DOC21/803589-25

13 October 2021

**EPA Advice on Environmental Impact Statement for proposed Snack Brands Manufacturing Facility, Orchard Hills (SSD-18204994)**

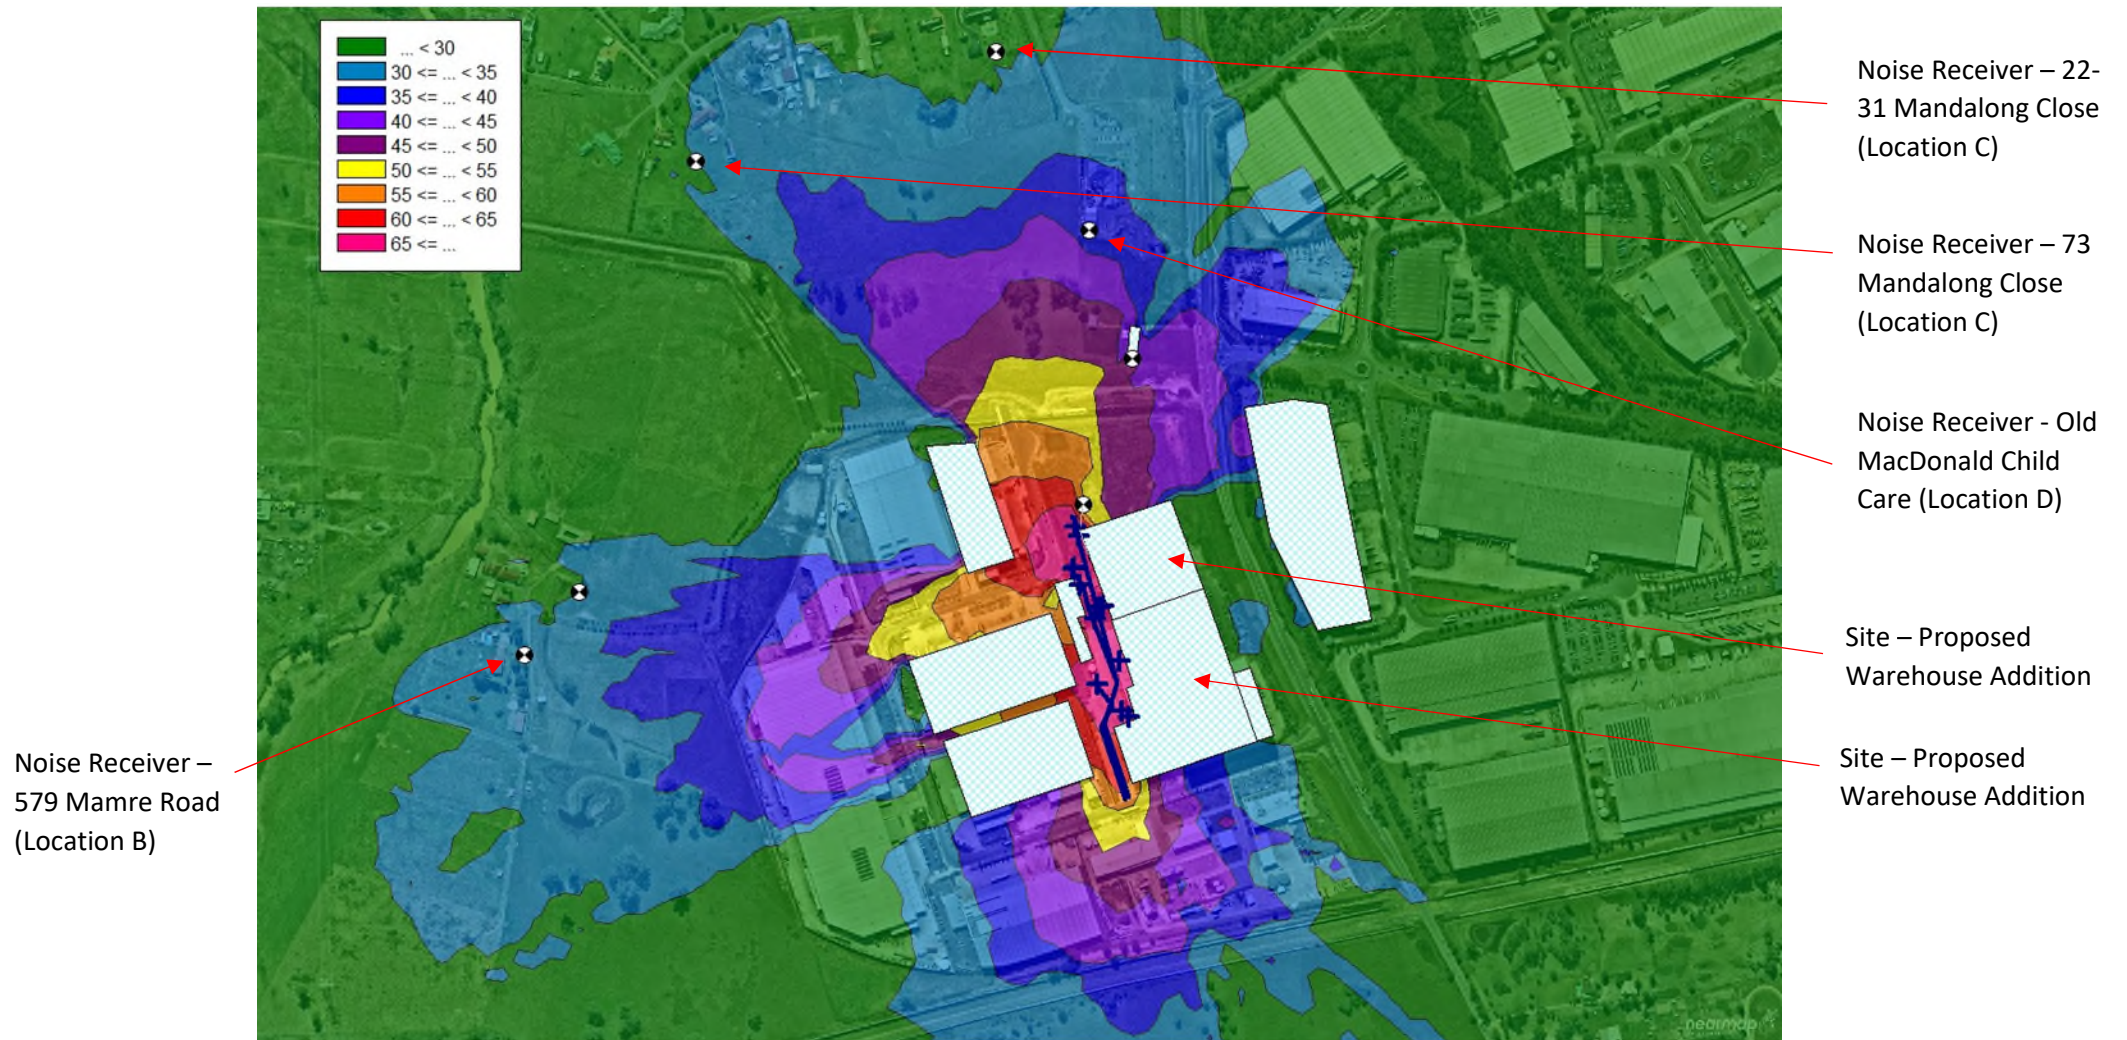
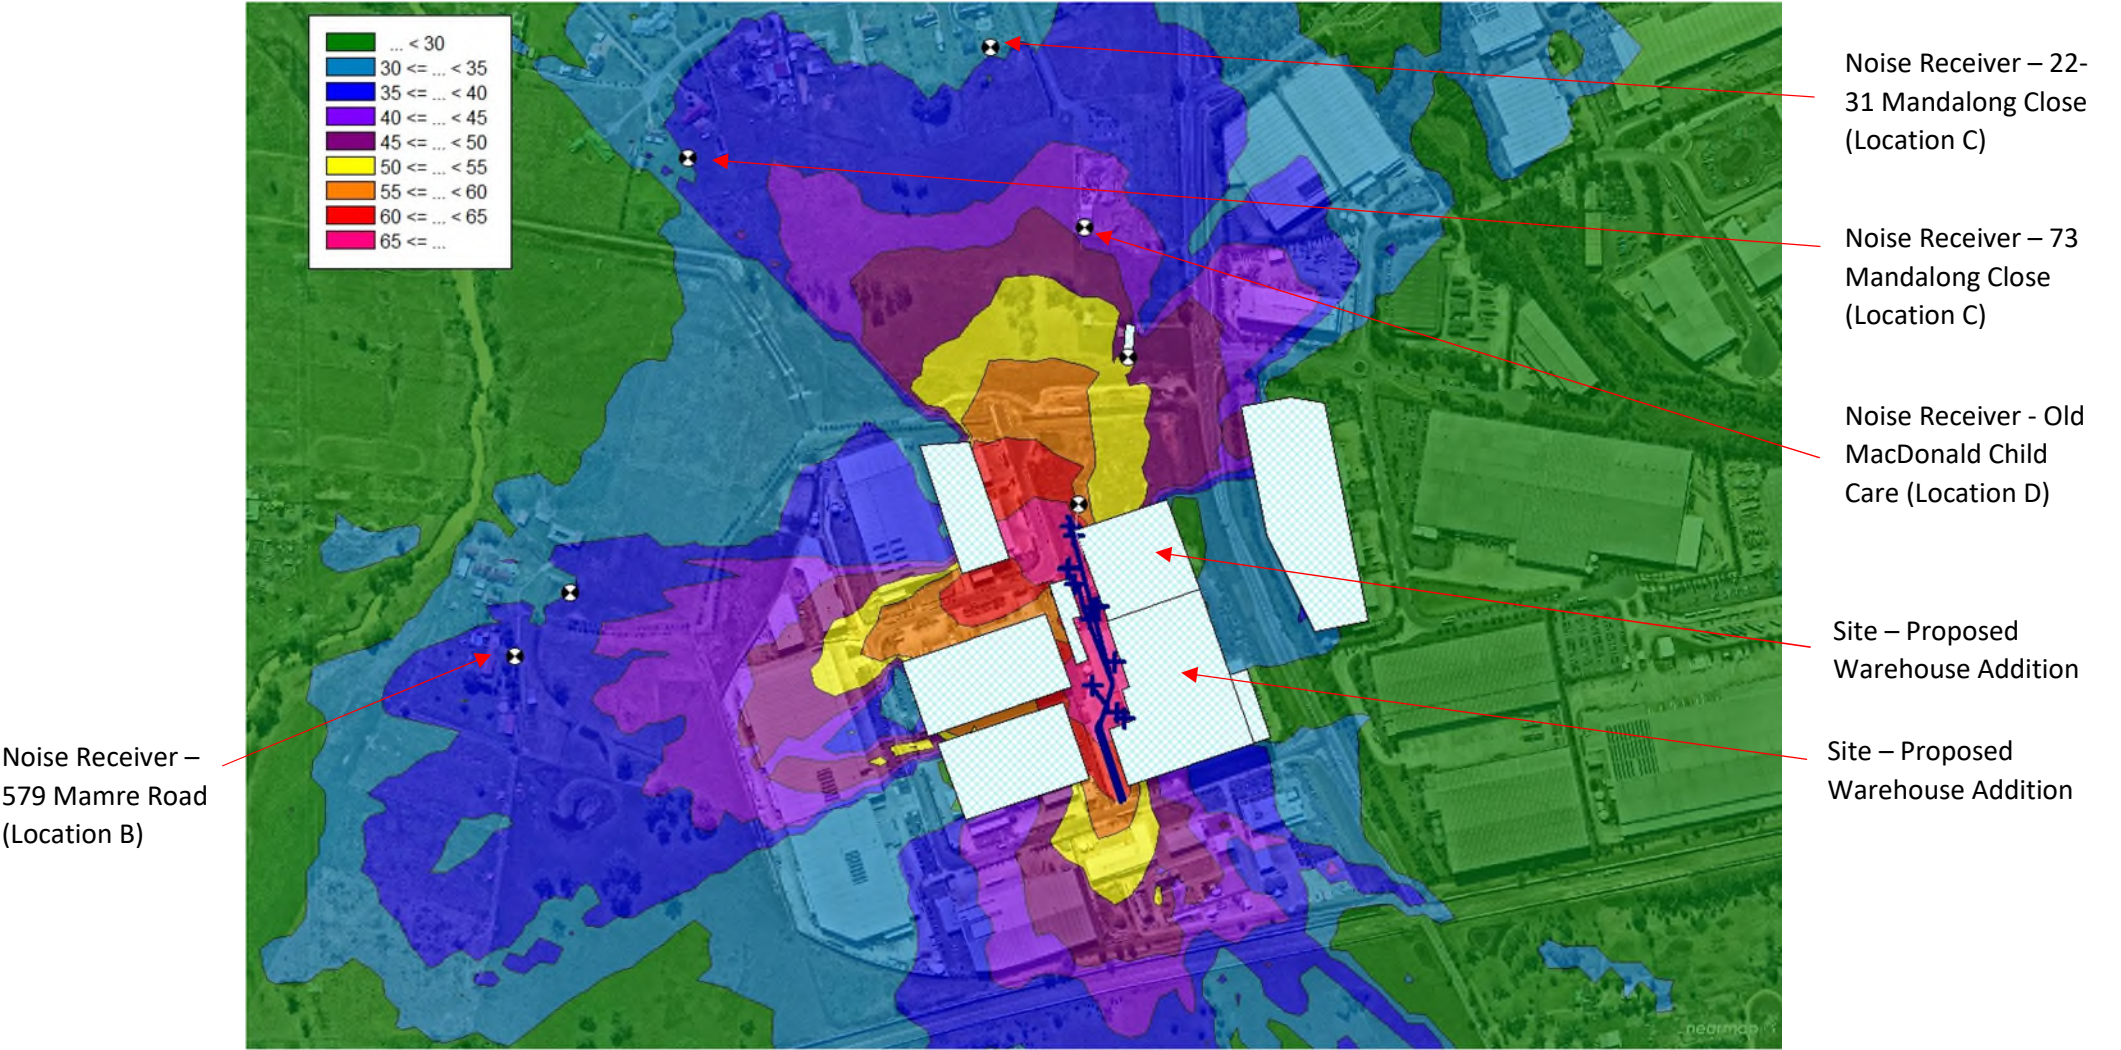
The NIA has selected two receivers (22-31 Mandalong Close and 73 Mandalong Close) as representative of all residential receivers on Mandalong Close. However, the noise contour plots in NIA Appendix F, appear to show that noise levels may be higher at other residential receivers on Mandalong Close than those two receivers assessed in the NIA.

From the noise contour plots in NIA Appendix F, it appears that some receivers on Mandalong Close may experience noise levels higher than those assessed in the NIA. The existing approval for SSD-9429 only nominates one receiver (the receiver at 65-73 Mandalong Close) where noise limits apply.

According to Table 4.5, the predicted noise level at 23-31 Mandalong Close under noise-enhancing conditions is 35 dBA, and at 73 Mandalong Close 34 dBA. Using the indicative noise level from the contour maps in NIA Appendix F, noise levels at other receivers on Mandalong Close could be up to 5 dB higher than those predicted at 23-31 and 73 Mandalong Close in NIA Table 4.5.

The architectural plans provided with the Environmental Impact Statement show a number of smoke fans, exhaust fans, cooling equipment and many other types of mechanical plant located on the proposed warehouse roof. However, it does not appear from the maps in Appendix F that any of this plant has been modelled on the rooftop and there is limited information in the rest of the report regarding this.

Figure 10 of the Environmental Impact Statement (EIS) shows the proposed layout of the development. There appears to be discrepancies with what is shown as modelled in Appendix F and where noise sources may be expected to be located.

- the NIA be updated to adequately identify and assess impacts on residential receivers on Mandalong Close.
- the point-to-point calculation for all residential receivers on Mandalong Close are presented and assessed in the NIA so that the impacts at all receivers in this area can be reviewed. The

- A labelled map showing the location of all modelled noise sources should be included in the NIA for both Leq and Lmax sources
- The location, type, amount, and other relevant information regarding mechanical plant should be provided in the NIA. The sound power levels for each type of plant should be included in the source emissions inventory. Where detailed information is not known, a conceptual sound power level could be used
